WEST SUSSEX COUNTY COUNCIL CONSULTATION

TO:	Arun District Council FAO: Mr S Davis
FROM:	WSCC - Highways Authority
DATE:	3 August 2020
LOCATION:	Land between 2b and 4 London Road Bognor Regis NEAR PO2
SUBJECT:	BR/131/20/PL Erection of a commercial unit at ground floor level with residential development of 3 no. bedroom flats above. This application is in CIL Zone 3 (Zero Rated) for flats & shop (Zero Rated).
DATE OF SITE VISIT:	n/a
RECOMMENDATION:	Advice
S106 CONTRIBUTION TOTAL:	n/a

JJR DESIGNS Limited

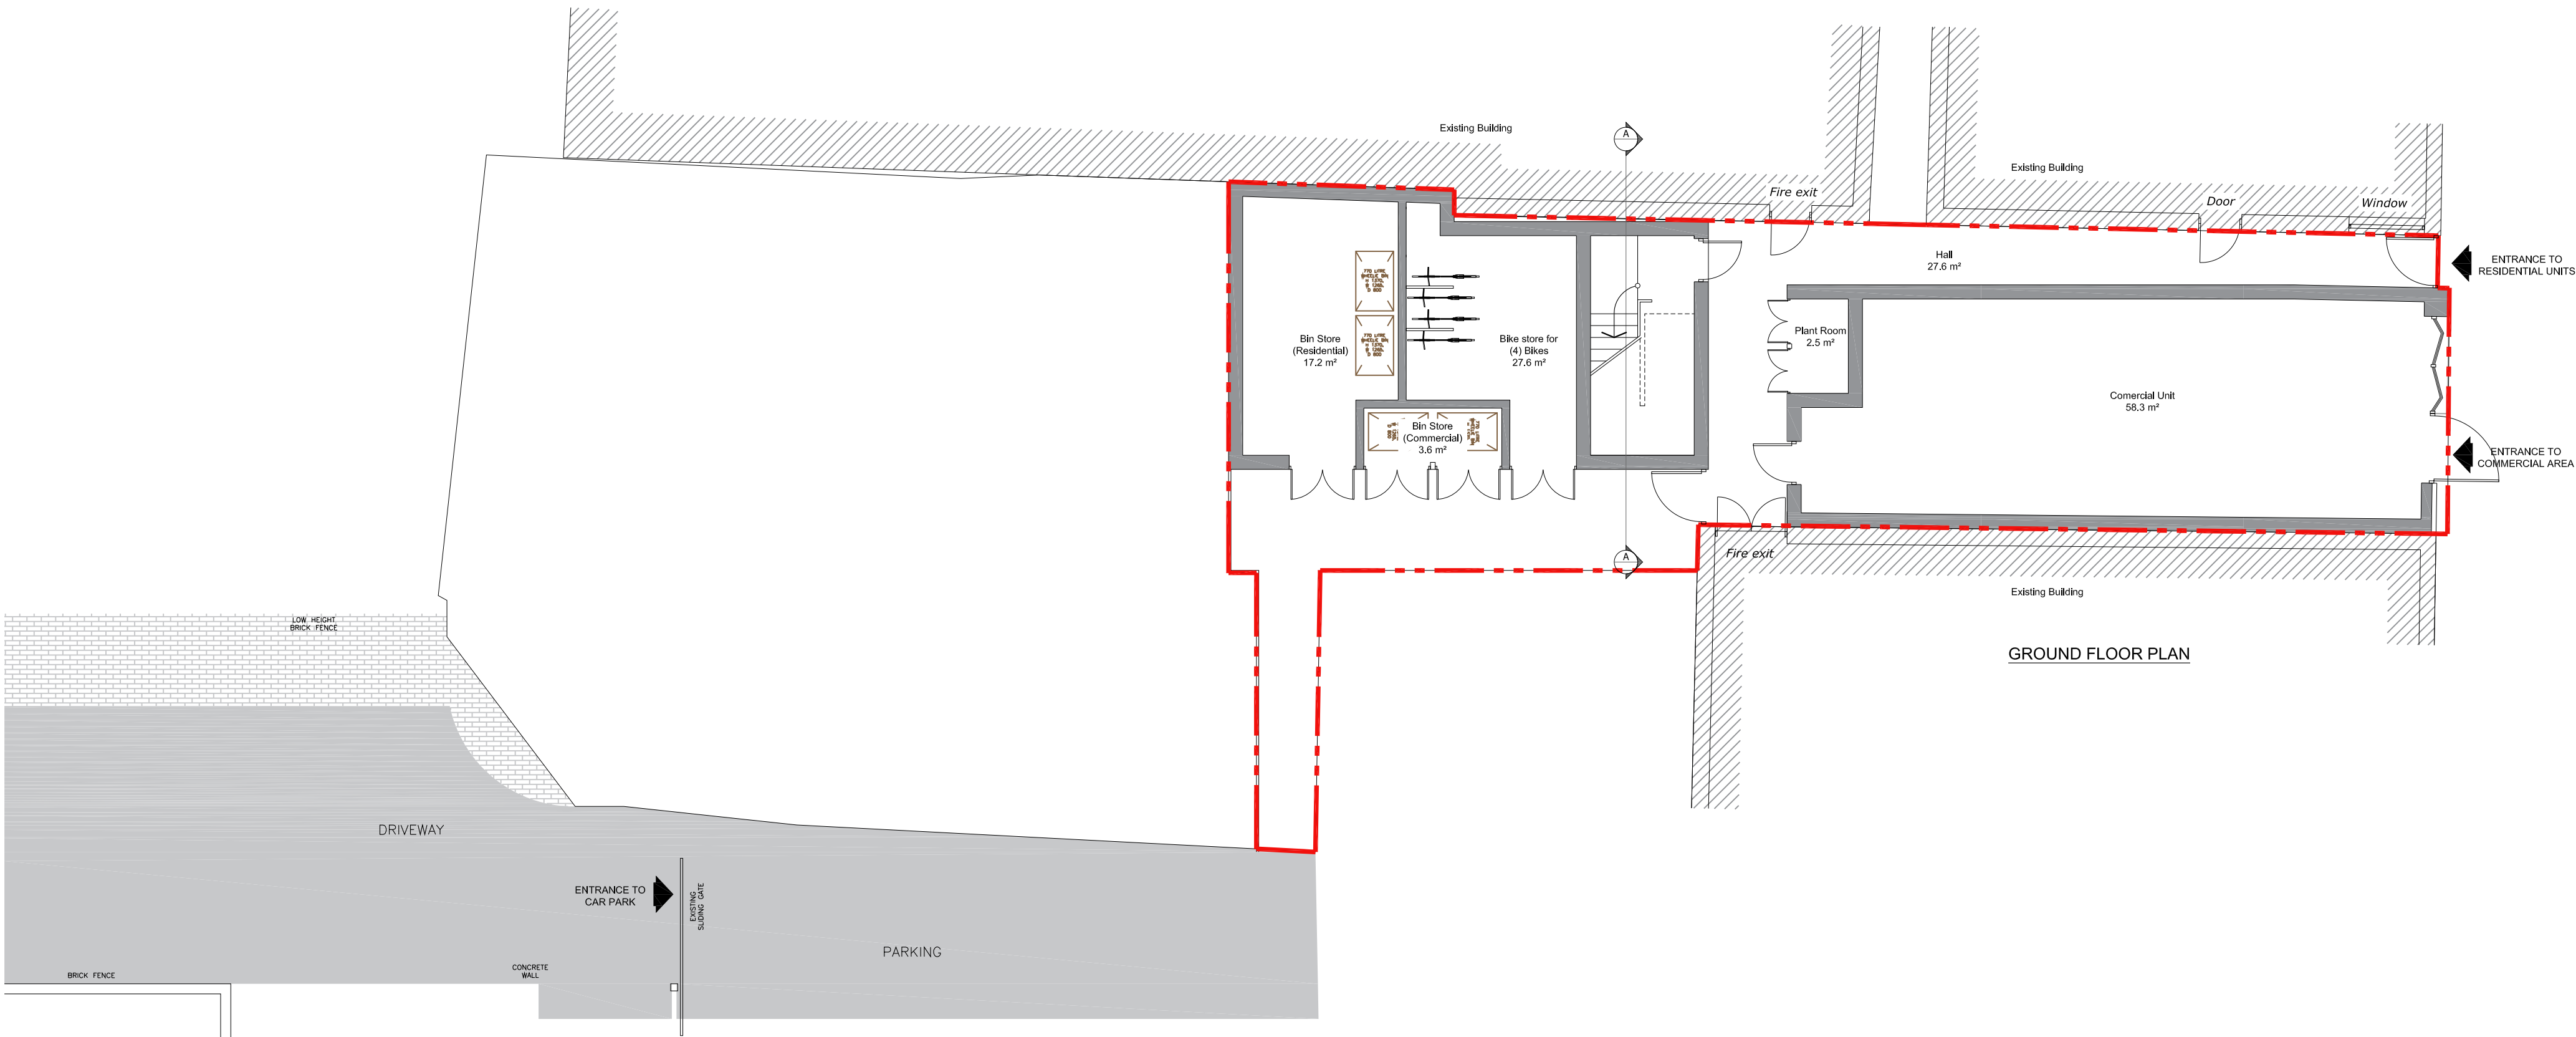
The plans detail a communal 4 cycle parking provision. This provision would be considered in line with Arun Parking Supplementary Planning Document.

No part of the development shall be first occupied until covered and secure cycle parking spaces have been provided in accordance with the approved planning drawings.
